DMRB GG119 - ROAD SAFETY AUDIT RESPONSE REPORT

Report Title: Ashgrove Road, Sevenoaks – Proposed Field Access, Stage1 RSA
Date: 01/06/2021
Document ref and rev: N02-siseve-RSADR 2021-06-01
Prepared by: Motion
Overseeing Organisation: Kent County Council

Project Ashgrove Road, Sevenoaks
Report Title Designer's Response to Stage 1 RSA
Prepared by
Name Steve Giles
Position Director
Signed:

Drawing:
 2008028-02A

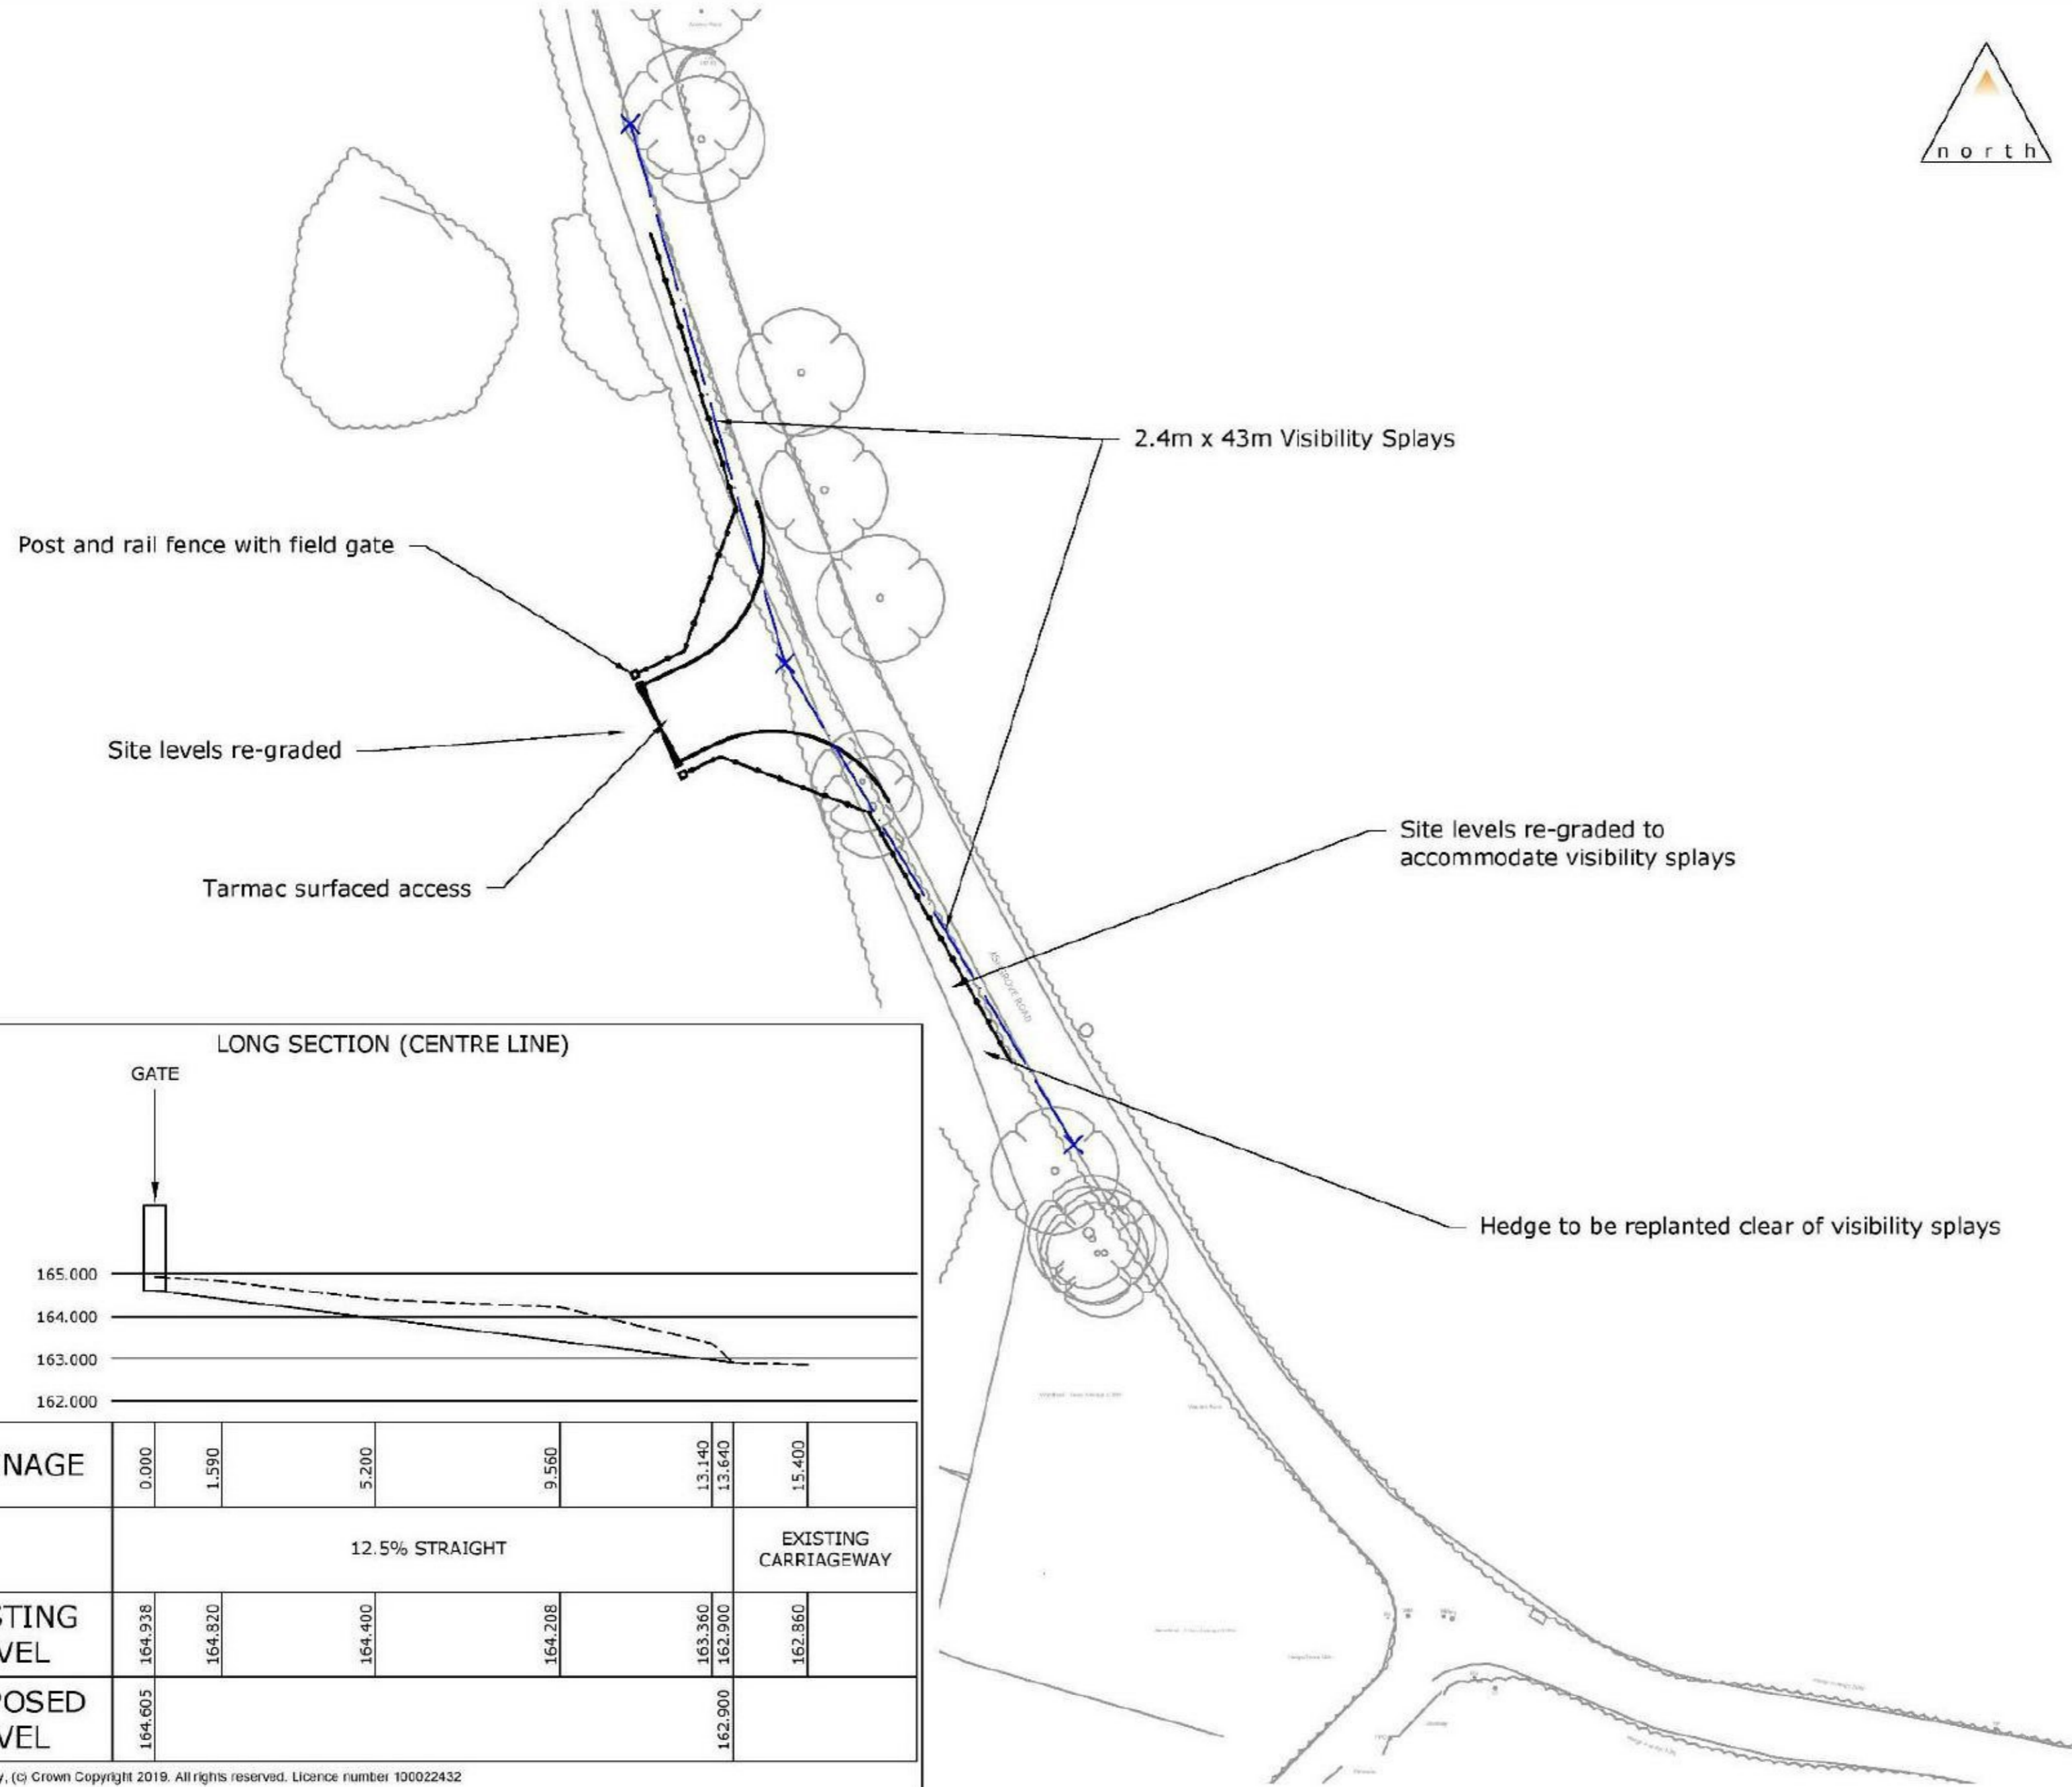
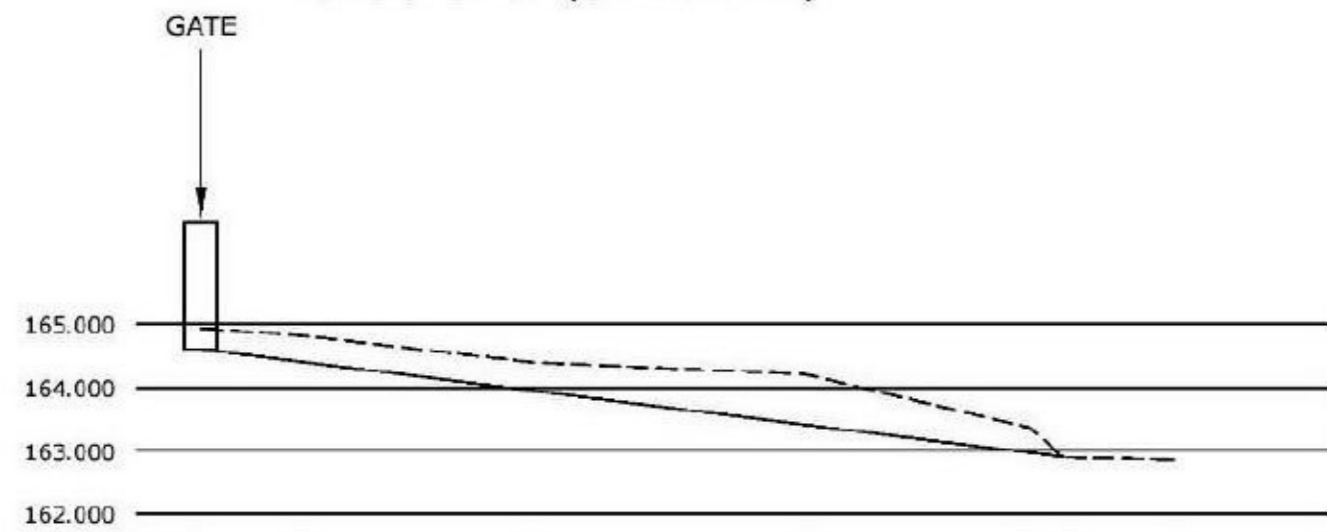
Item No.	RSA Recommendation	Design Organisation Response	Overseeing Organisation Response	Agreed RSA Action (design organisation and overseeing organisations agreed action to the problem)
5.3	The steep gradient at the access should be slackened	Noted and agreed. In drawing no. 2008008-02 rev. A (attached) the access gradient has been reduced to 12.5%, lowering the gate by 330mm. The surrounding ground within the site will be re-graded to accommodate this.
